A303 Amesbury to Berwick Down Case Team
National Infrastructure Planning
The Planning Inspectorate
Temple Quay House
Temple Quay
Bristol
BS1 6PN
Reference : 20019751
3rd May 2019

Application by Highways England for an Order Granting Development Consent for the A303 Amesbury to Berwick Down

I represent Amesbury Abbey Group who are the owners of Amesbury Abbey, Grade I listed building and 8 ha of registered park and gardens Amesbury Abbey Park Grade II*.

Drawing Title
HIA FIGURE 11
KEY MAP INDICATING THE LOCATION OF ASSET GROUPS IN RELATION TO THE ZONE OF THEORETICAL VISIBILITY OF THE SCHEME

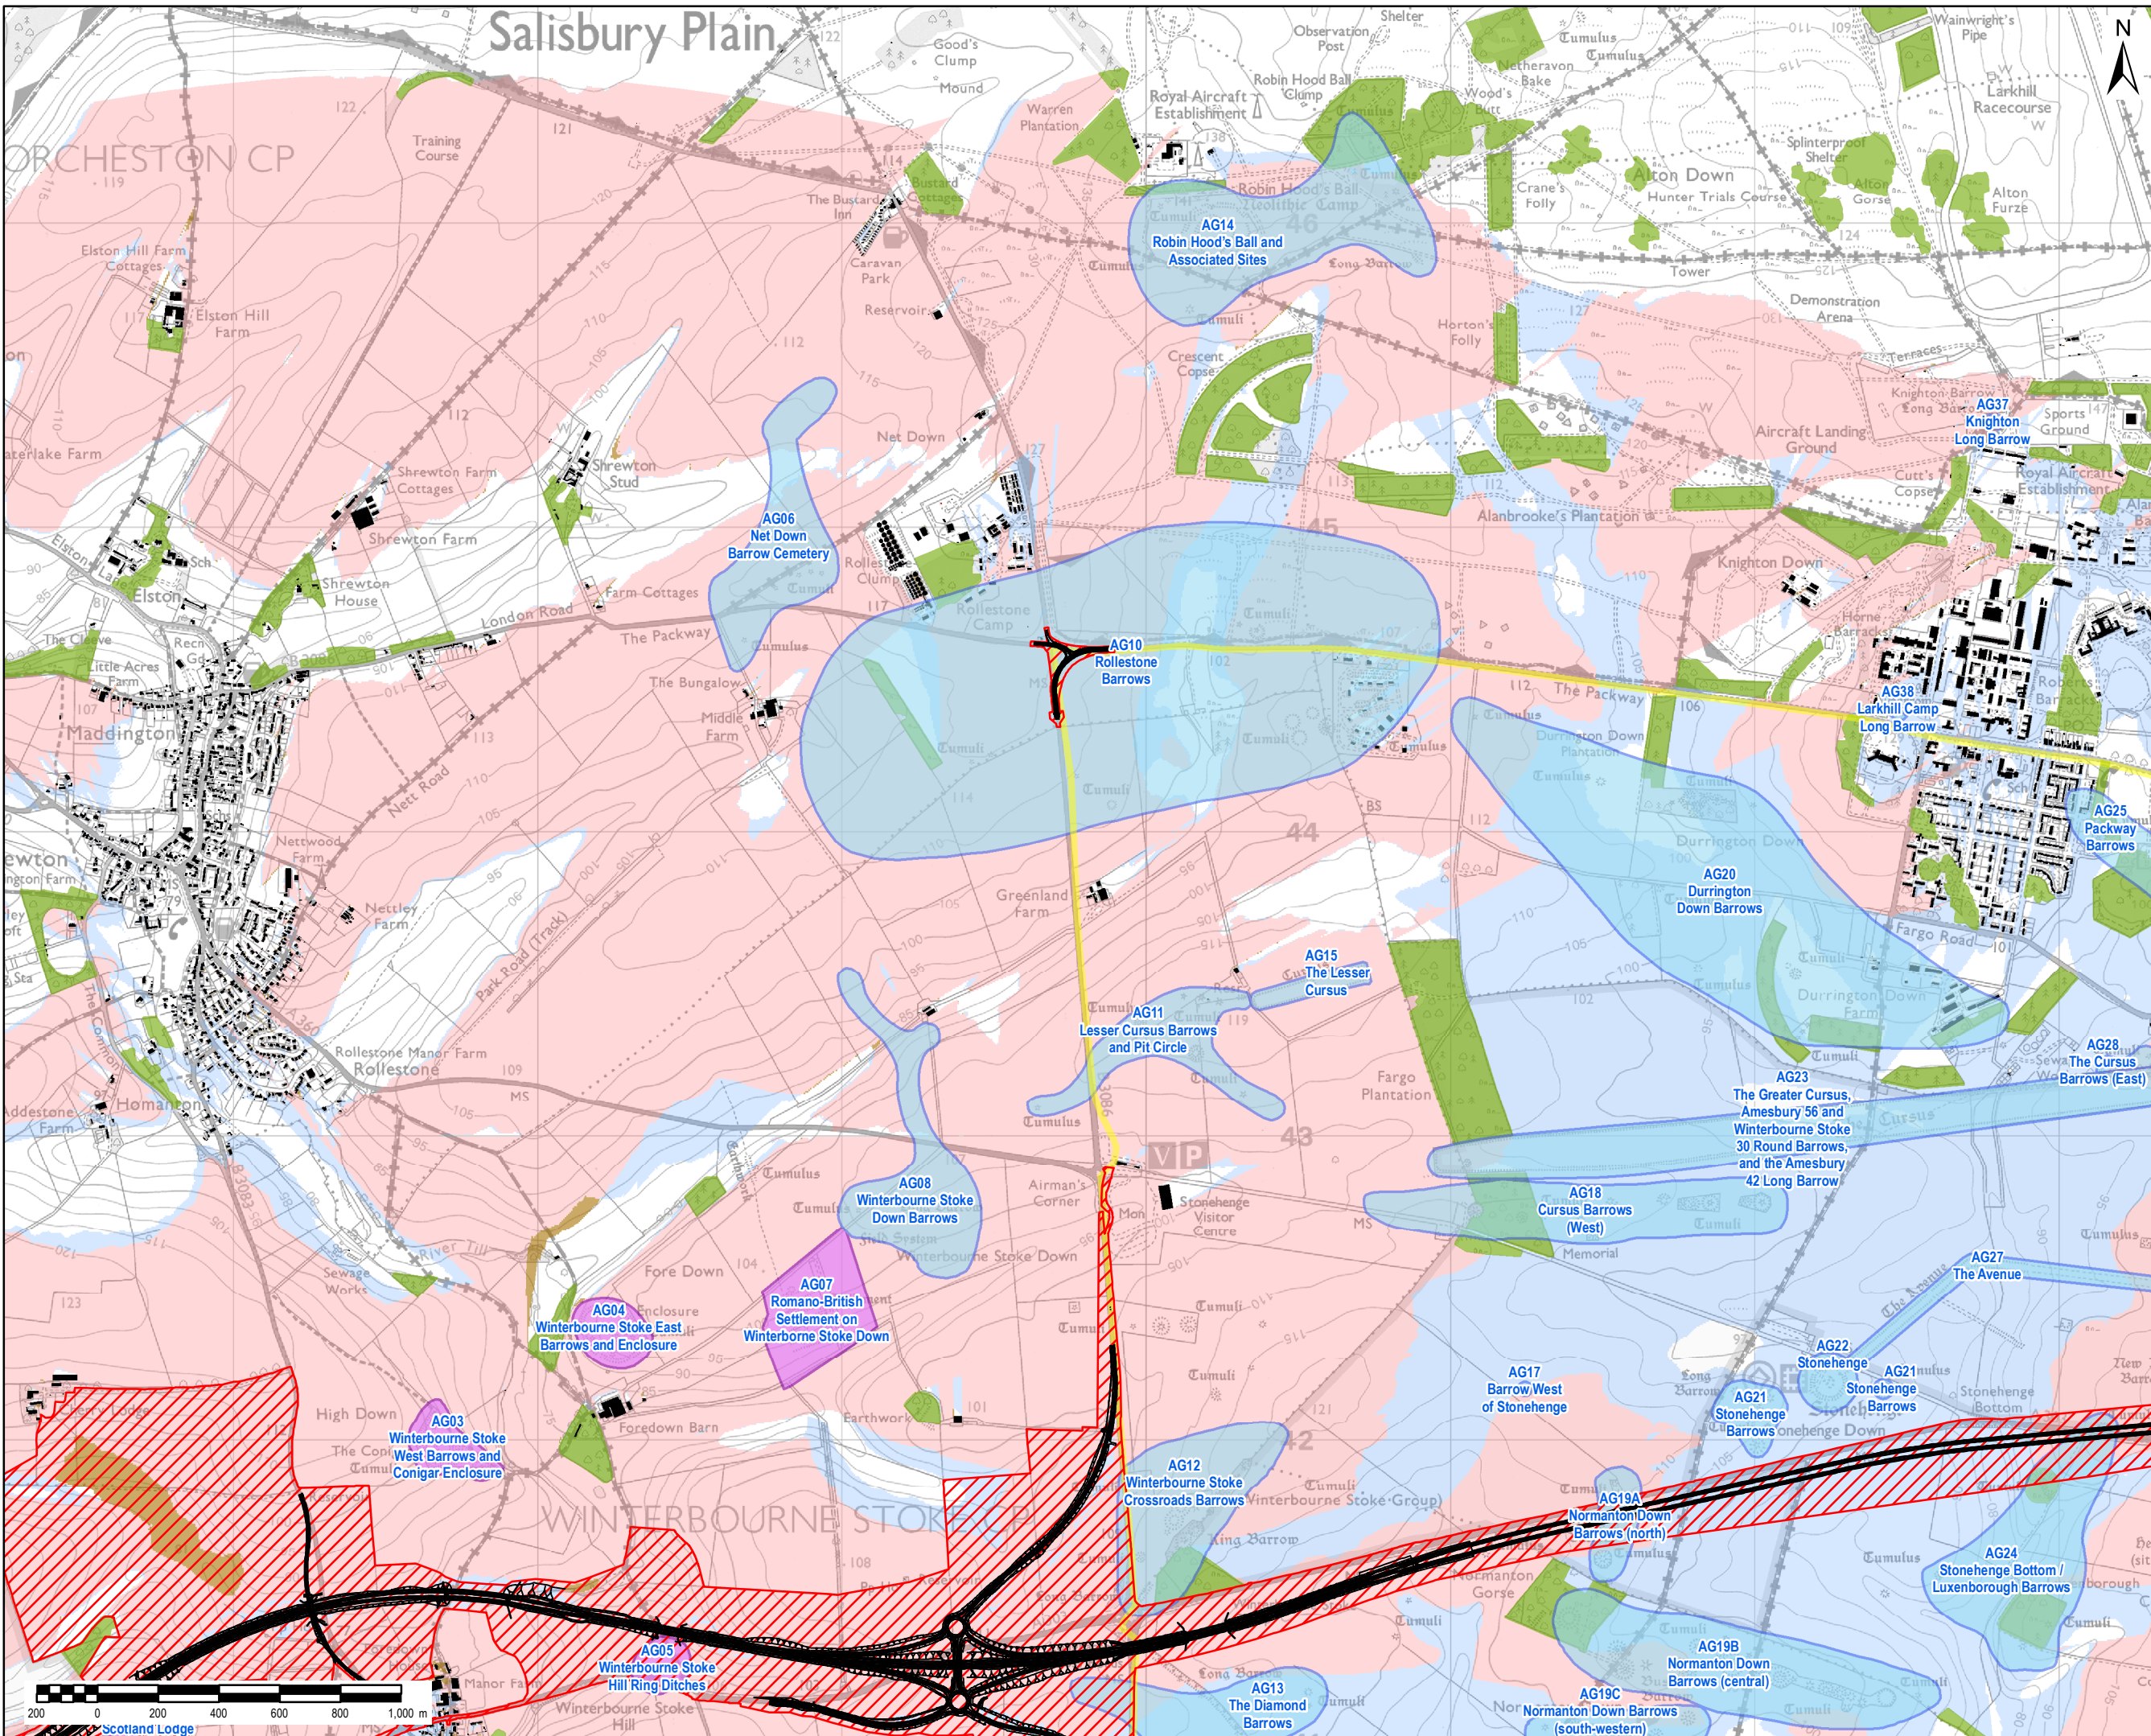
HIA Figure 11B shows the location of Asset Groups in relation to the zone of theoretical visibility of the scheme. The park is not shown within the zone of theoretical visibility.

The only heritage asset in Amesbury Abbey Park which is being considered is Vespian's Camp, no consideration has been given to the impact of the scheme on the setting of Amesbury Abbey Park nor the other heritage assets within it. This is justified on the basis of the zone of theoretical visibility of the scheme which has incorrectly concluded that the A303 and the flyover will not be visible from the park.

The Scheme's Zone of Theoretical Visibility (ZTV) established by the Landscape and Visual Impact Assessment, is incorrect in showing at figure 7.9 that there is no visibility of the present A303 nor any future visibility of the flyover and consequently its conclusions of impact and harm are incorrect .
